Your Ref: OWPC6931
Our Ref: P/86/15/PL 11-08-2015
Please ask for:
Mr S Davis

1 No. 2 bedroom semi-detached bungalow
11 Abbotsbury Pagham

Thank you for your internet representation made on 15th September 2015 which has been recorded as '**an objection**' with the comments as follows:

Proposed Floor Plan & Site Plan

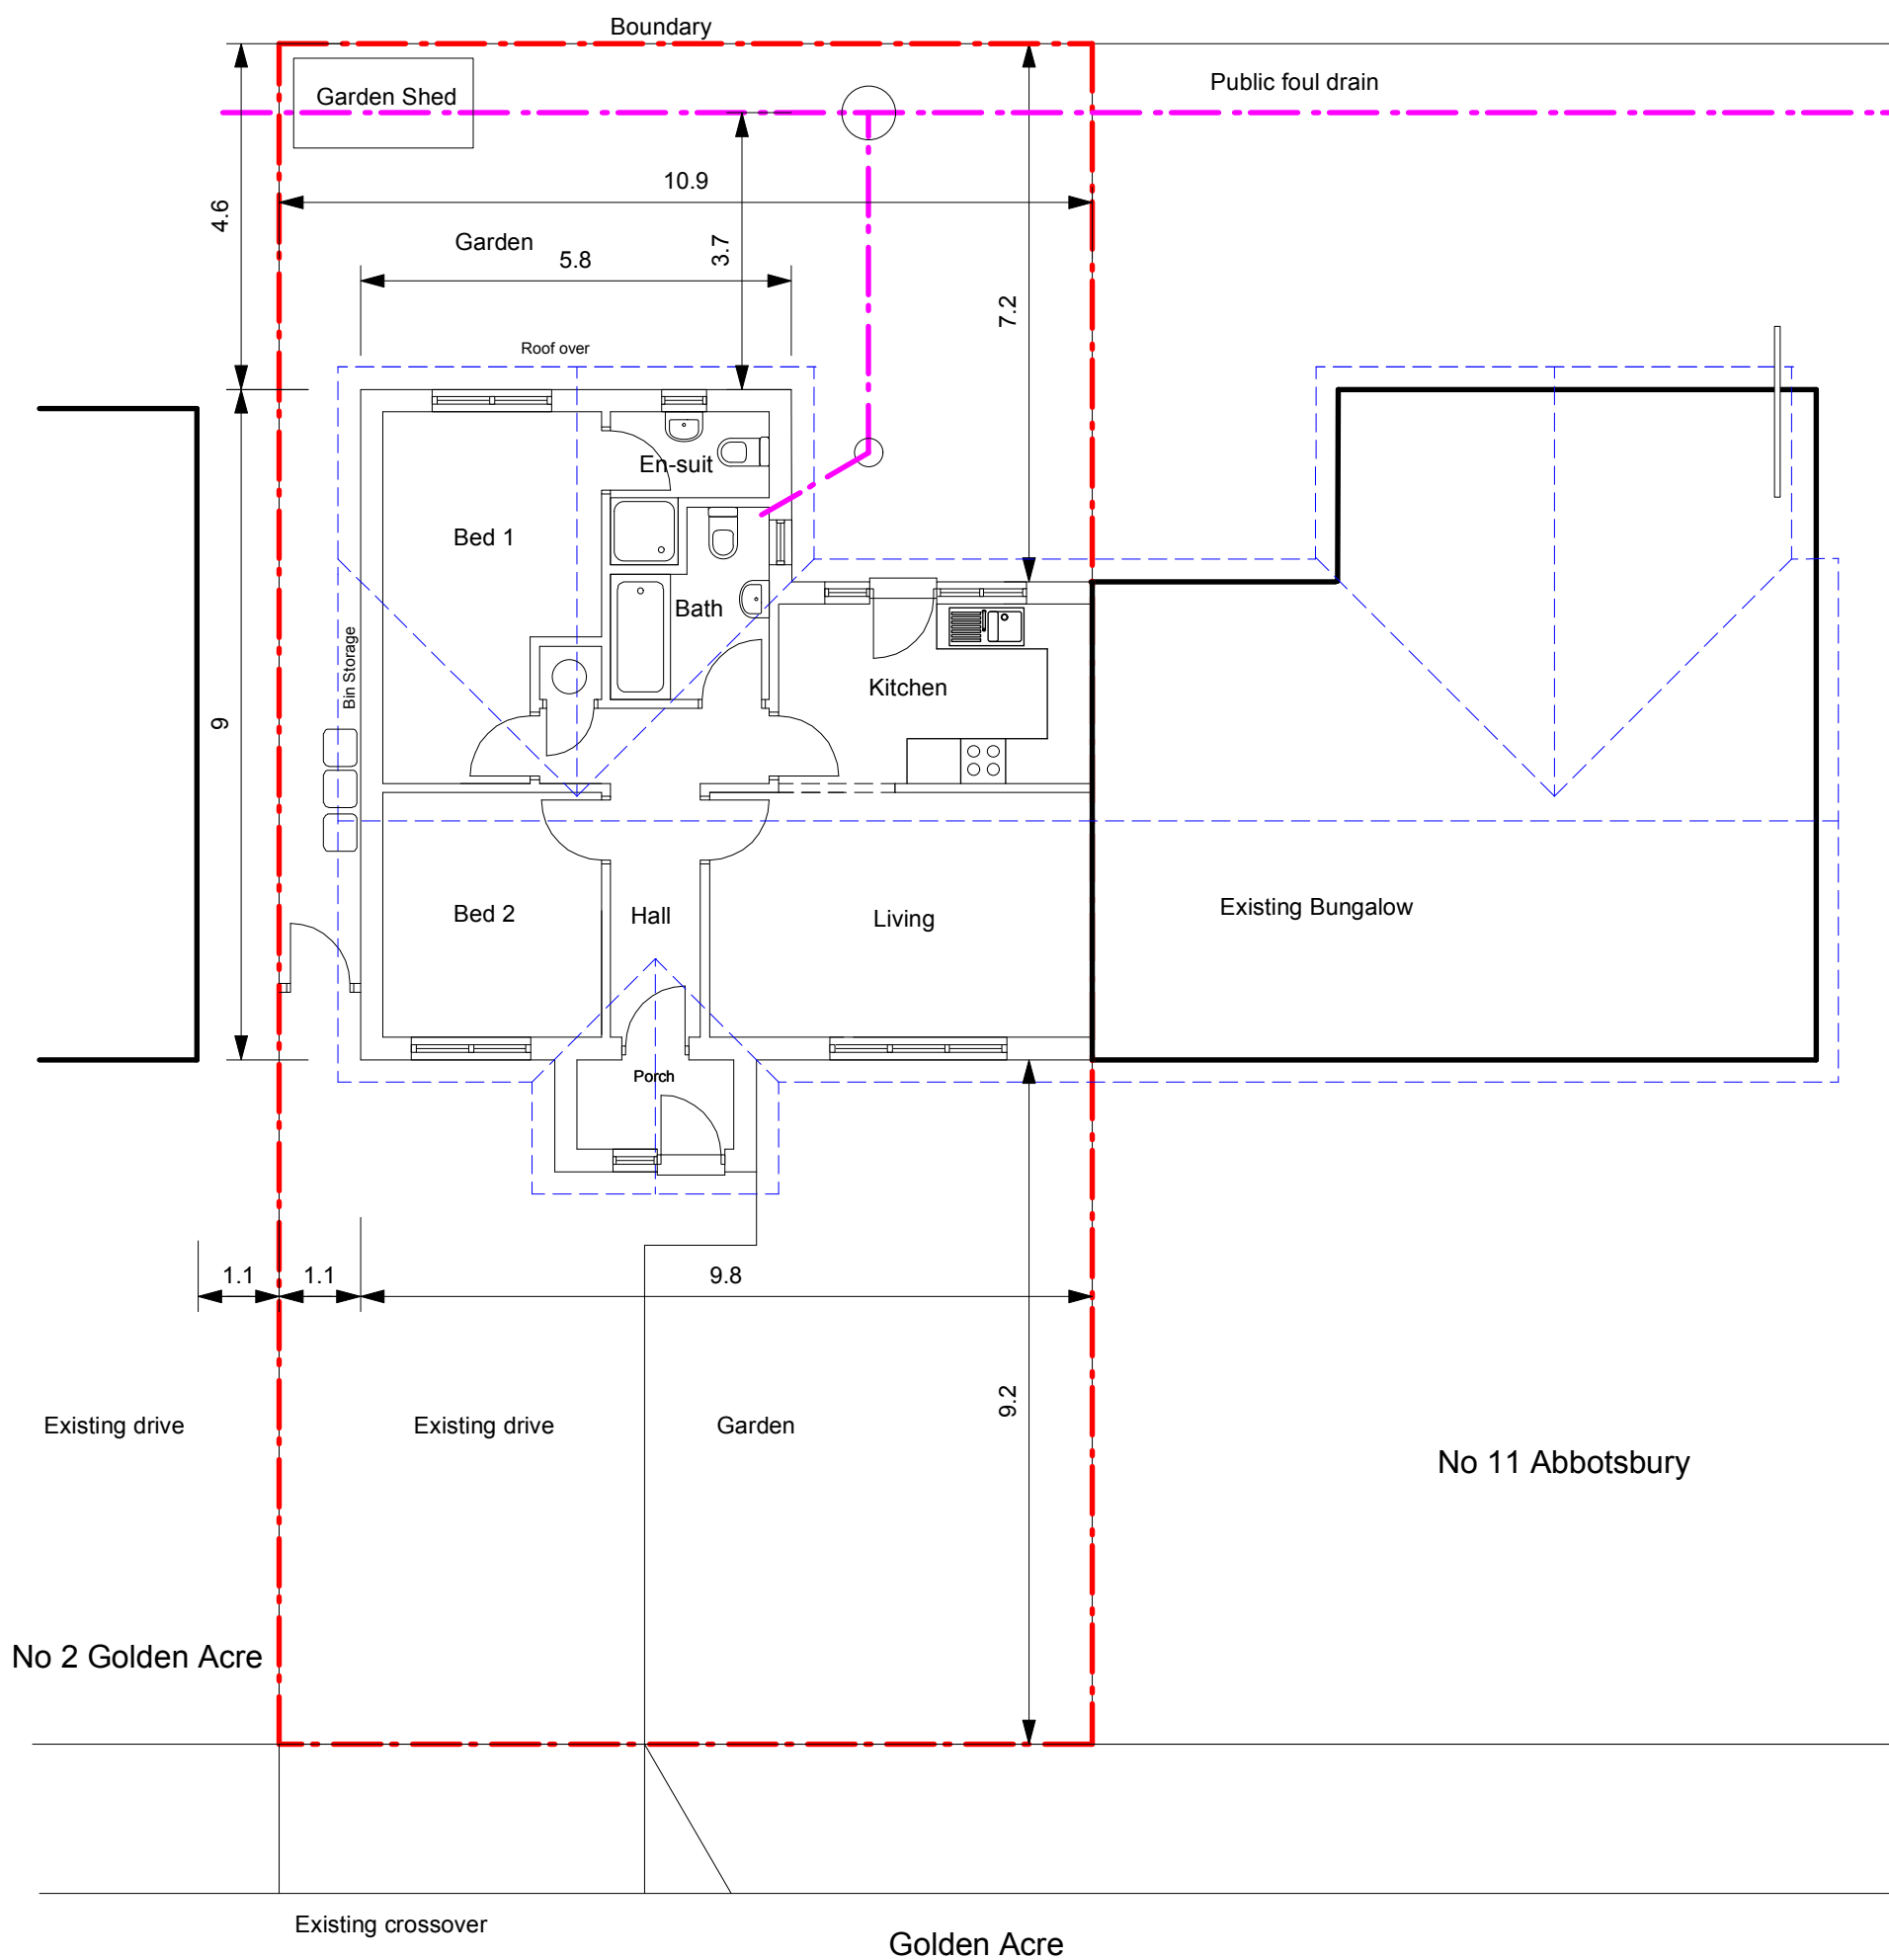
- 4) *The measurement on the plans state that our walkway at the side of our property, is 1.1 metres but is in fact 1.2 metres, so are they planning on building over the boundary?*

- 5) *Will the boundary wall behind the garage be demolished? As it does not state this on the schedule/plans only the garage. Will you erect a new boundary wall to match the existing?*
If a new boundary wall was to be erected what height would this be? As the privacy into our kitchen/bathroom windows could be invaded if they were too low.

Proposed Side Elevation
South West

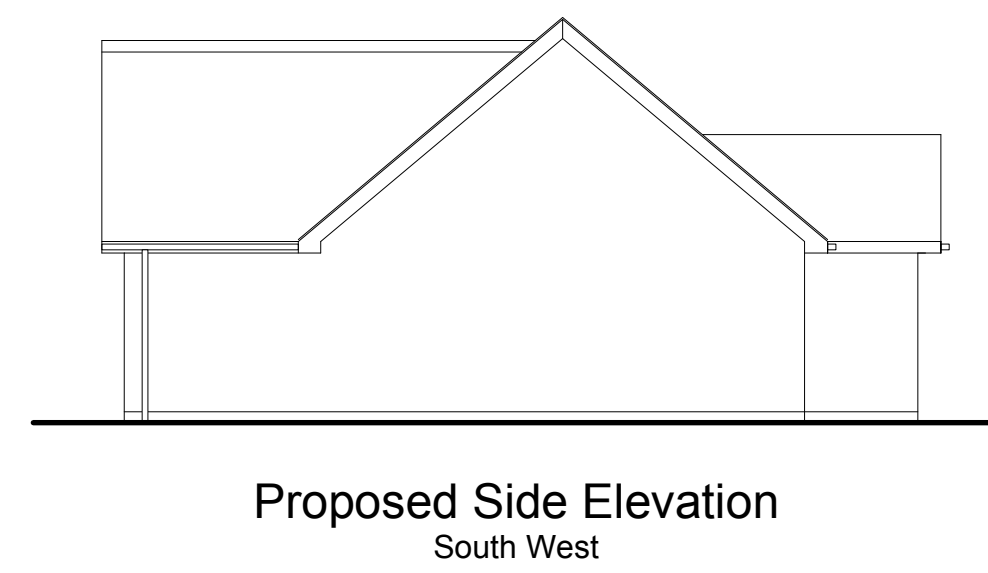
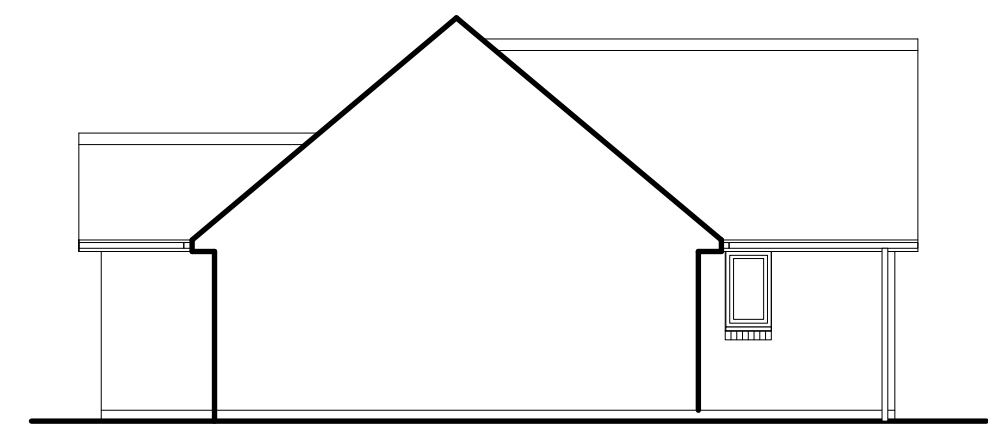
- 1) *We are concerned about the impact of loss of light, into both our Kitchen and 2 bathroom windows at all times, which face directly towards the new build.*

- 2) *Also the loss of light first thing in the morning into the rear garden.*
- 3) *We would also be concerned if they were able to build into the roof/loft area either now or in the future, as this would invade our privacy into both our living area and rear garden as this would directly overlook both.*

- 1) *If the plans get approval white cladding could be placed on the side of the apex facing the side of our property to bounce light back into our windows, this could possibly help with the loss of light?*
